TfNSW reference: WST24/00395/001
Your reference: SSD-53293710

**SSD-53293710 – Mallee Wind Farm - Access via Silver City Highway / Arumpo Road, Wentworth
Local Government Area – Response to EIS**

Attachment 1

FIGURE J.1
Location and Conceptual
Layout of Proposed TWA
Facility

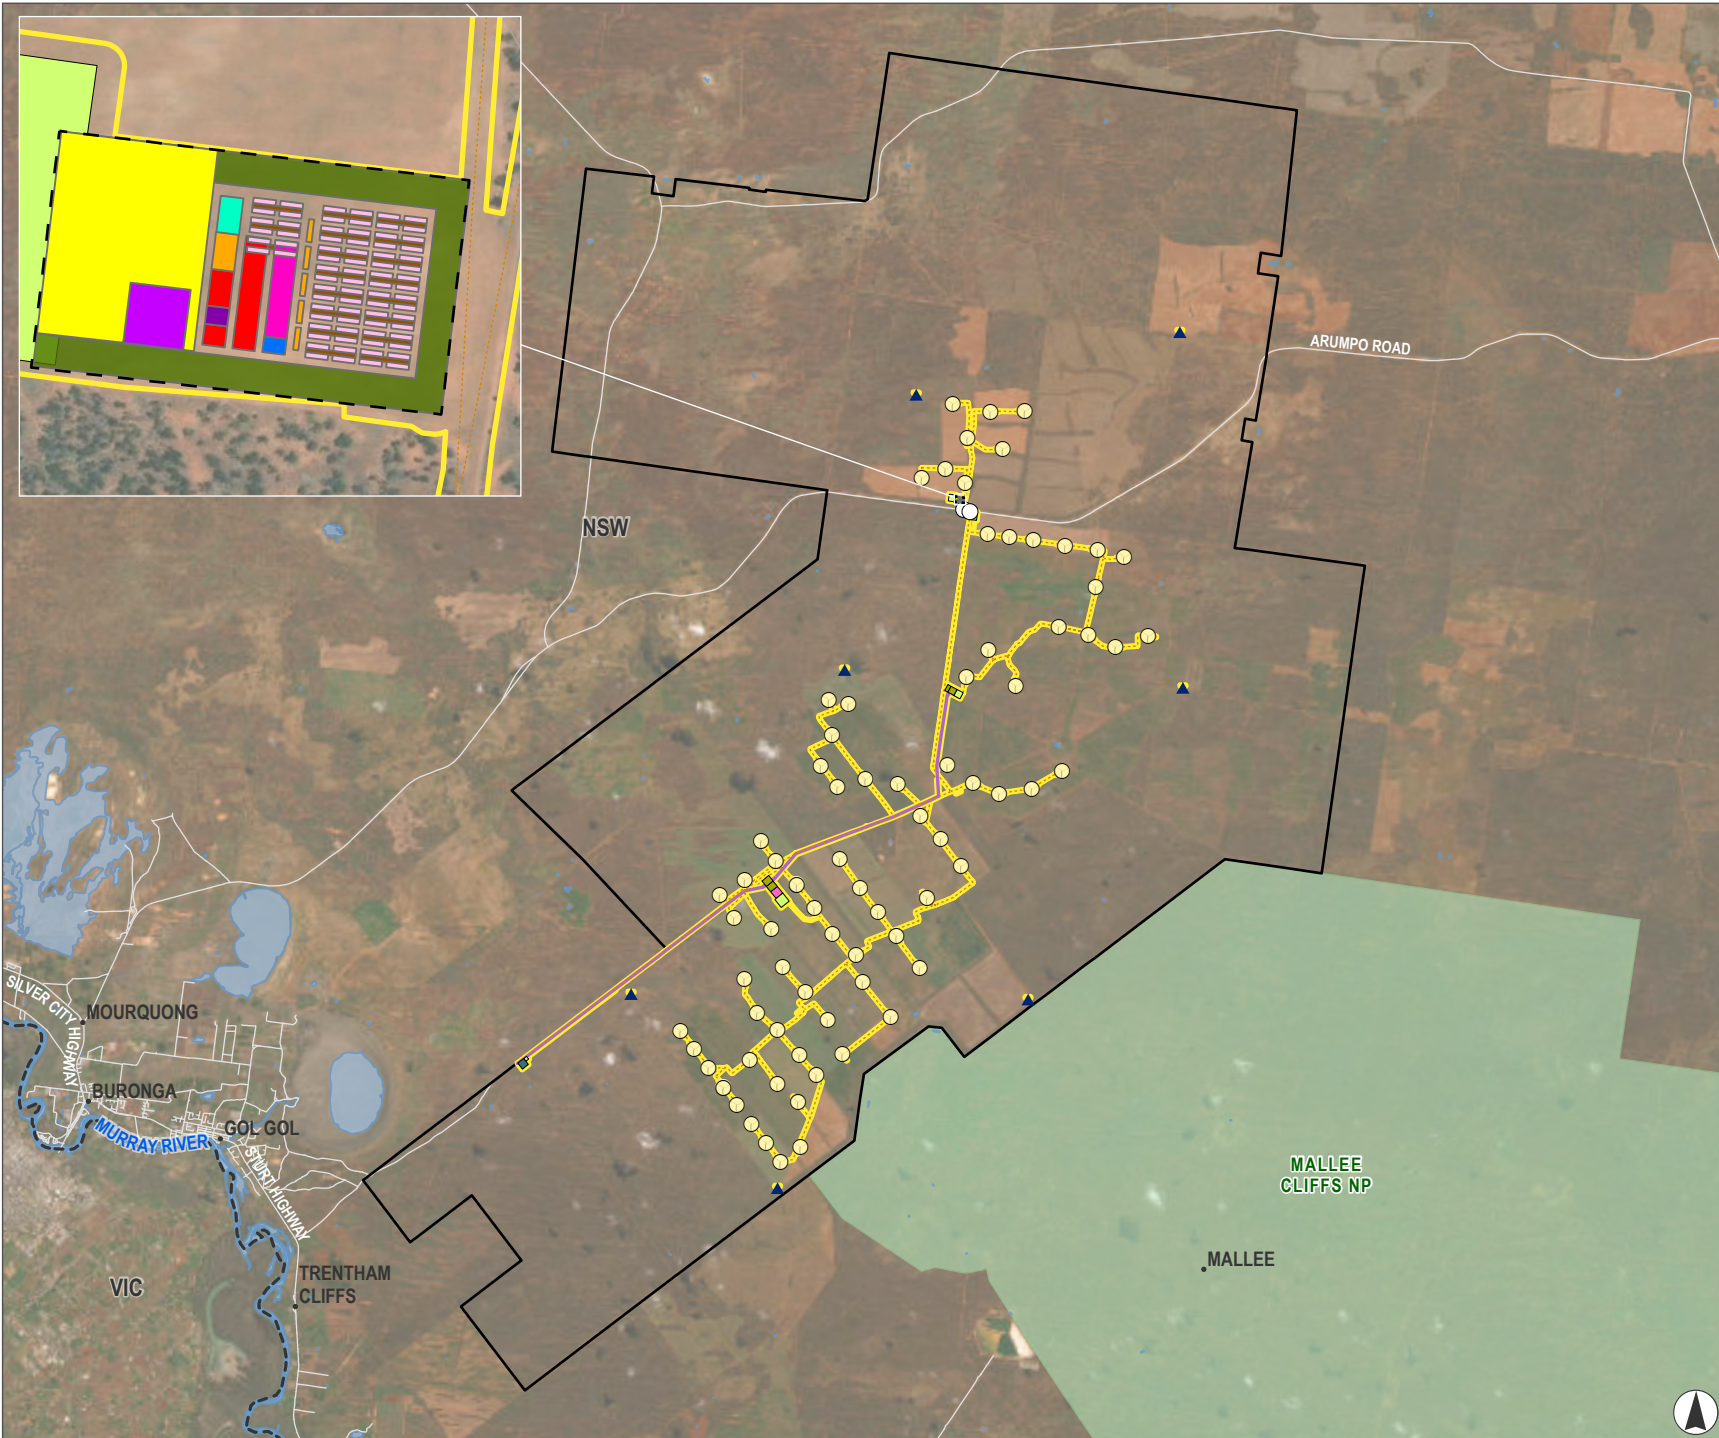
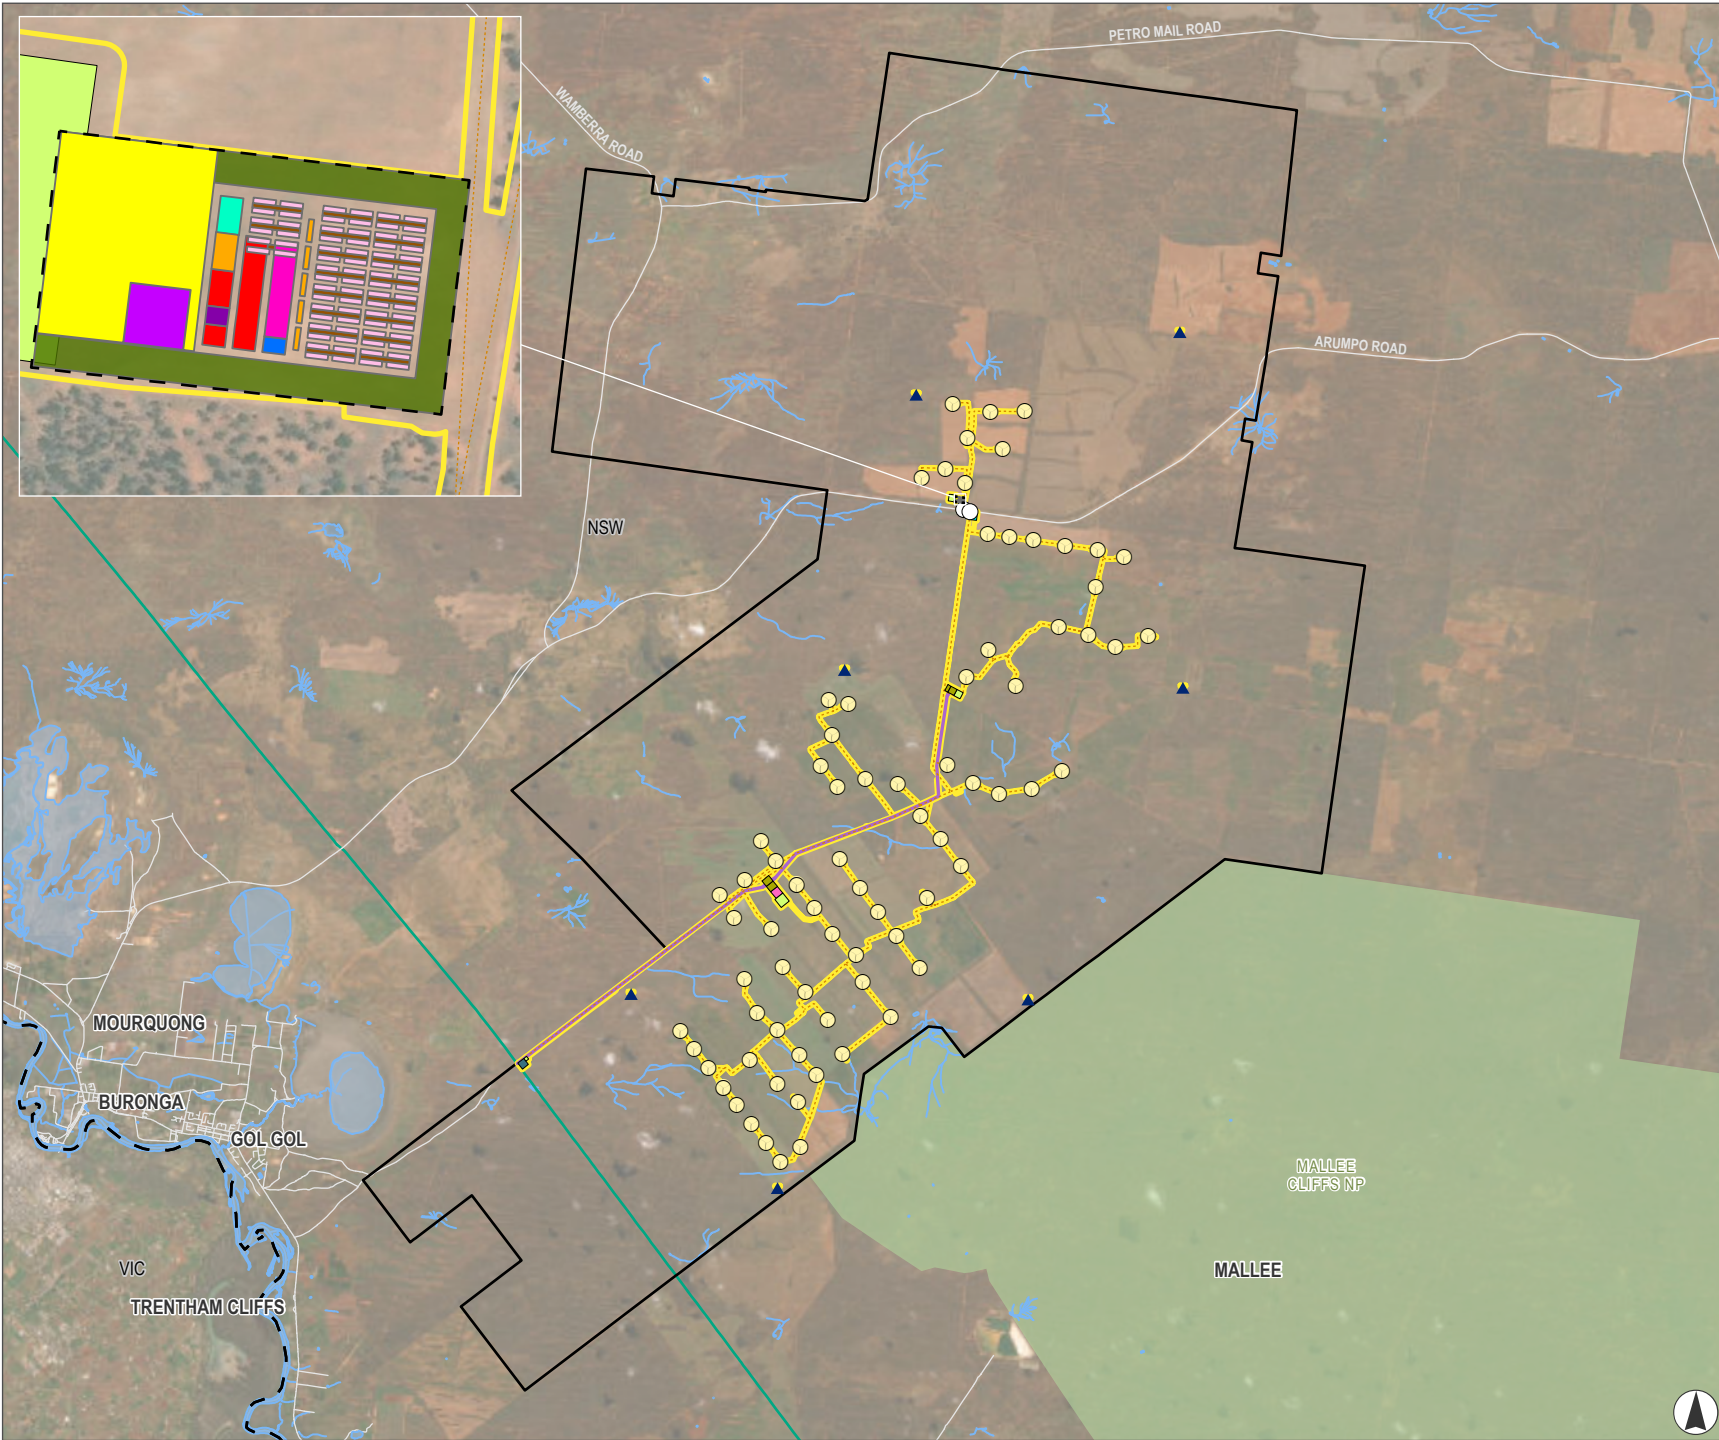
- b. Section 1.2.2 notes that a temporary workforce accommodation will be provided “if required”. The application is to provide detail on the scenarios that would determine requirement of the facility and provide specific detail including location, timing (would it be part of pre-construction minor works) and traffic volumes for the camp (traffic volumes should be inclusive of any staging, parallel construction activities while the camp is being constructed, the traffic volumes post completion of the workforce accommodation camp and any parallel activities that will occur post completion of the workforce accommodation.

- c. Noting that the project proposes optioning of the accommodation camp then both the with the accommodation camp and without the accommodation camp scenario is required to be assessed inclusive of any changes to the strategic concept designs.

FIGURE A.15
Sturt Highway roundabout
at intersection of Carey
Street, Euston – Road
Upgrade

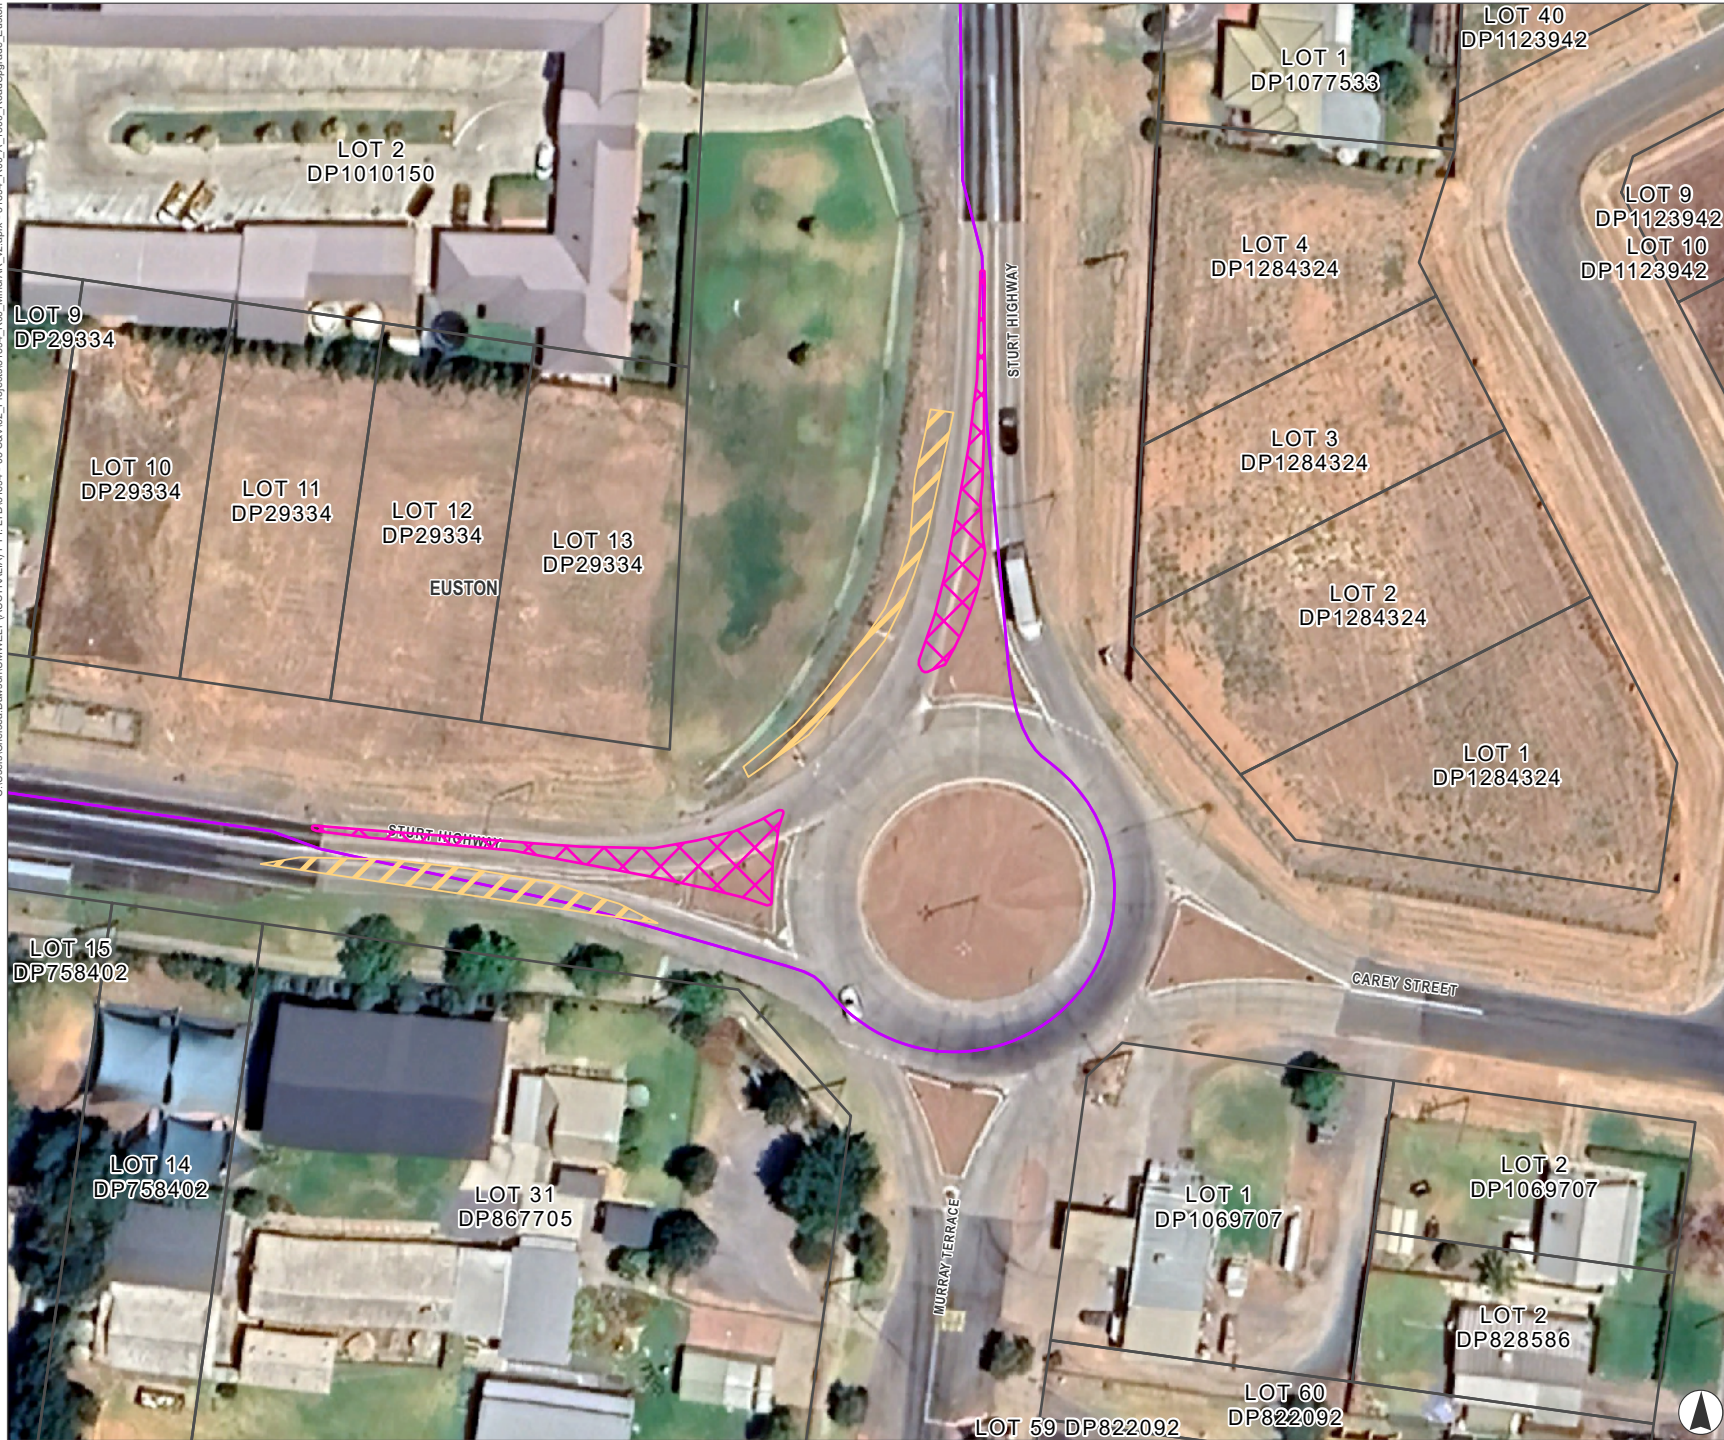
- k. Concept diagrams are required for the works to roundabouts along the Sturt Highway including at the intersection of Carey Street /Sturt Hwy and at the intersection of Sturt Highway and the Cobb Highway.

Figure 32 - Sturt Hwy onto Dansons Rd

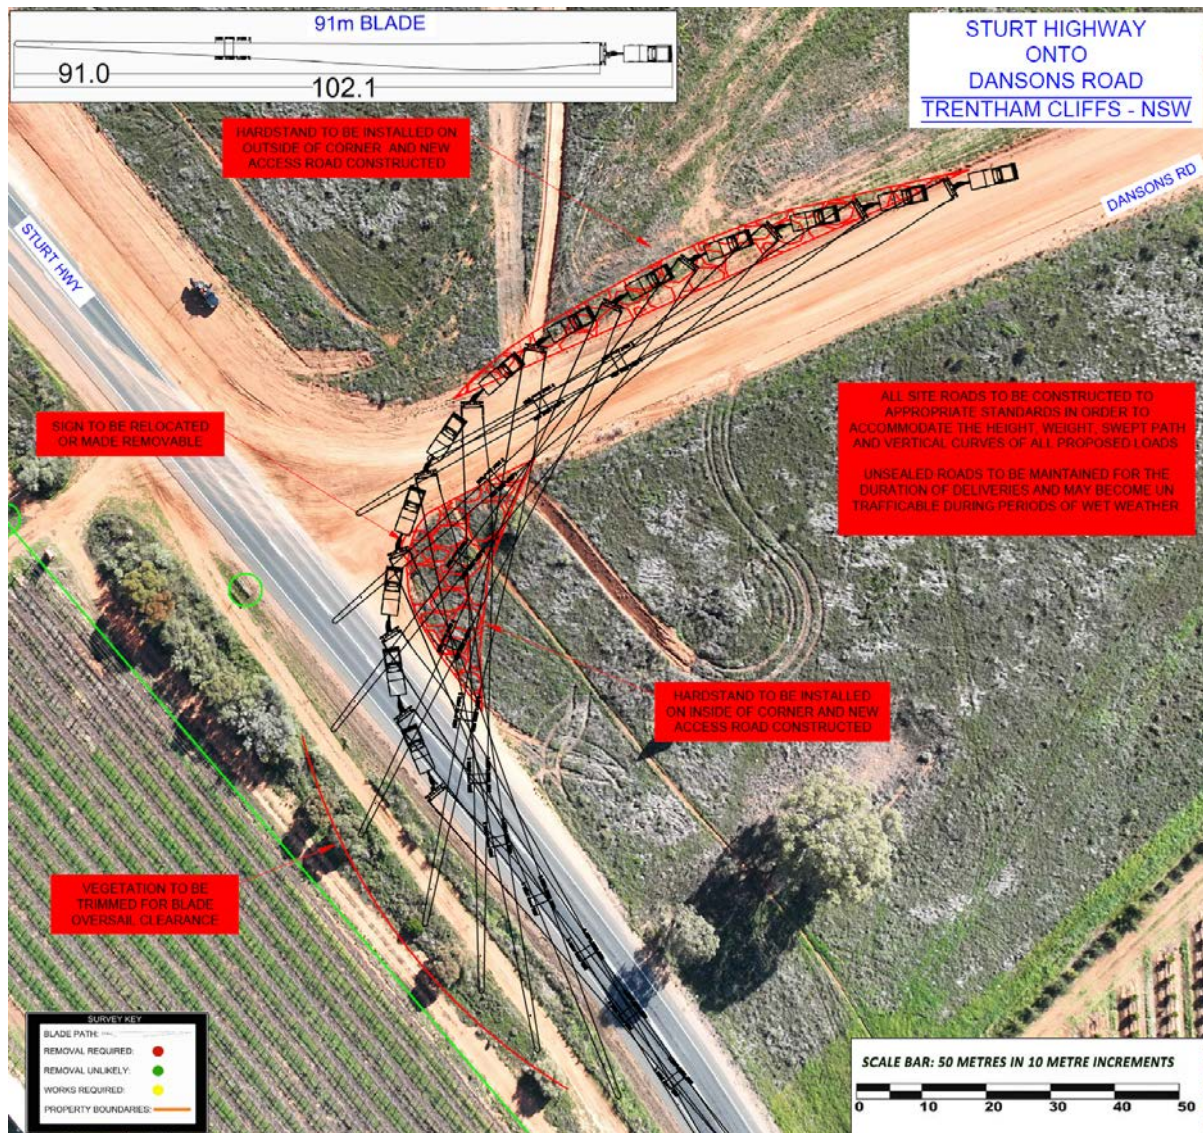
- d. The TIA in the accompanying route study identifies the intersection of the Sturt Highway and Danson’s Road as a possible access point to the site. The study identifies that further assessment is required to determine the routes suitability. The Response to Submissions must clarify if this intersection is to be used by the project and for what purposes. If proposed to be used for the project, a full assessment of impacts, similar to that provided for the Arumpo Road / Silver City Highway intersection will need to be provided. Traffic mitigation measures and strategic concept designs are required to accompany the resubmission of the revised TIA.

Figure 66 - Silver City Highway onto Arumpo Road

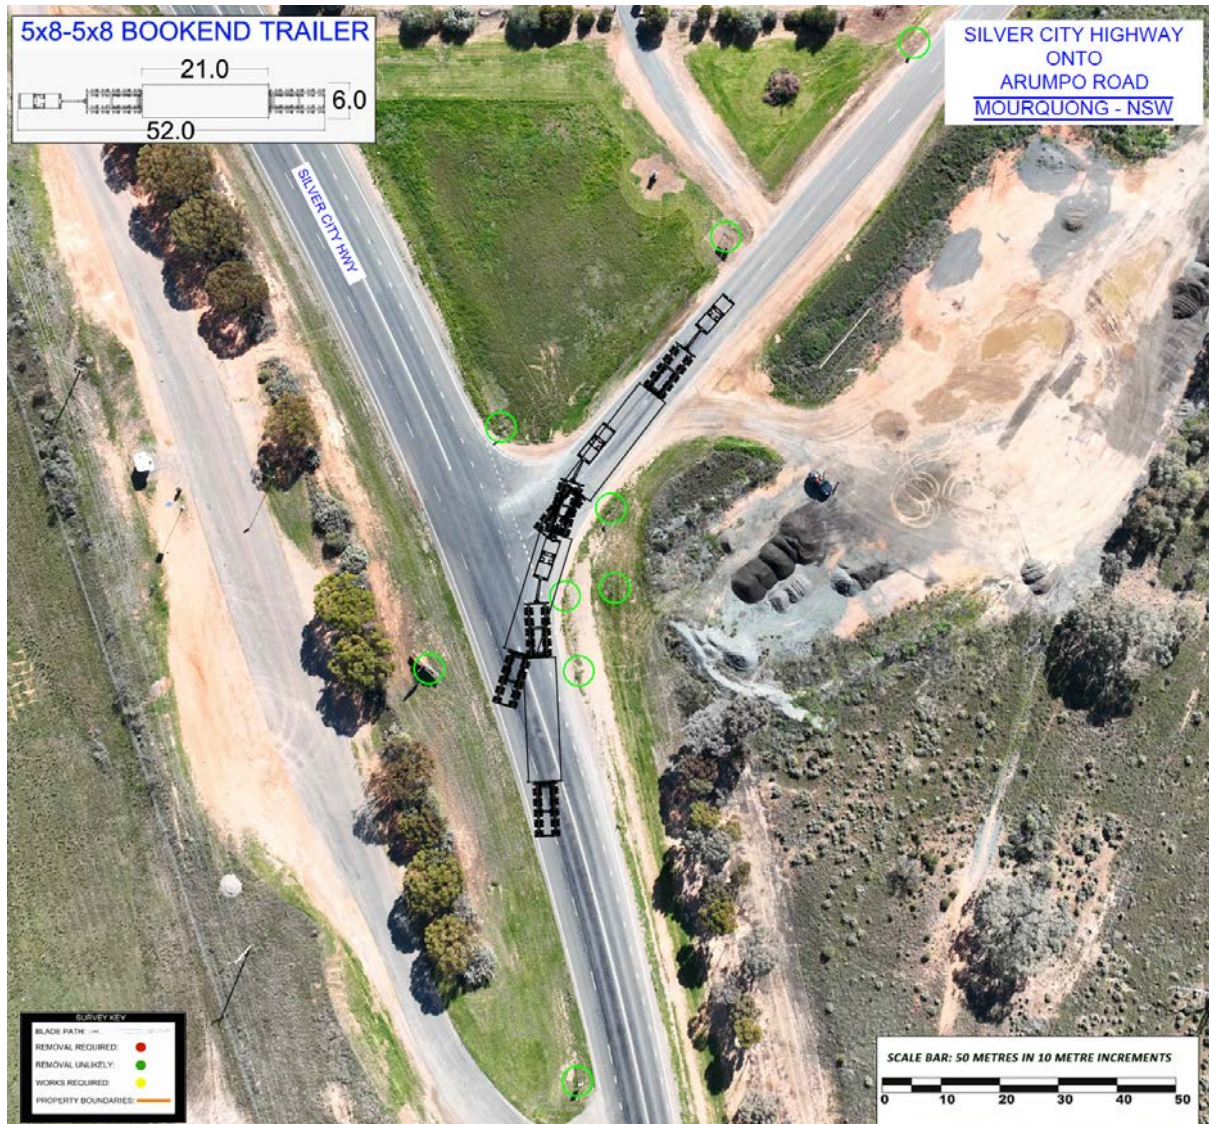
The strategic concept design for the proposed intersection of the Silver City Highway and Arumpo Road will need to be updated in line with the following:

- a. The applicant proposes to increase the use of the existing treatment, please review this to ensure it meets minimum Austroads requirements in *Austroads Guide to Road Design, Part 4A* and *Austroads Guide to Traffic Management Part 6*.

- b. The layout for the intersection will need to be amended to comply with the A value within Table 7.2 of *Austroads Guide to Road Design Part 4A*. The current A value is 55m which is introducing a reverse curve movement. The A value is to be increased to ensure It is tangential and not introducing a reverse curve movement to conform with Austroads.

- c. The current design proposes a short chevron on approach into the rest area egress. The departure chevron line markings must be increased in area to conform with *Part 4A of Austroads Guide to Road Design*. A widened shoulder that complies with Austroads is to be included within the revised design.

- d. The design does not identify how the northern portion of the existing intersection where there are two existing northbound lanes will be tied into proposed changes to the road geometry. In addition, the second auxiliary lane is too short to be an acceleration lane or to be used as an overtaking opportunity. Please revise in accordance with *Austroads Guide to Road Design Part 4a*.

- e. The right turn from Silver City Highway onto Arumpo Road requires signs to be relocated or made removable on the inside of the corner of turn. The design is to be revised to address this issue.

Swept paths are to be provided for the Silver City Highway / Arumpo Road Intersection for the design vehicle demonstrating the concurrent turn movements in all directions and for the check vehicle (the largest high-risk OSOM) demonstrating that the check vehicle will complete the arc within the pavement and the offset requirements without creating additional impacts to State road assets.
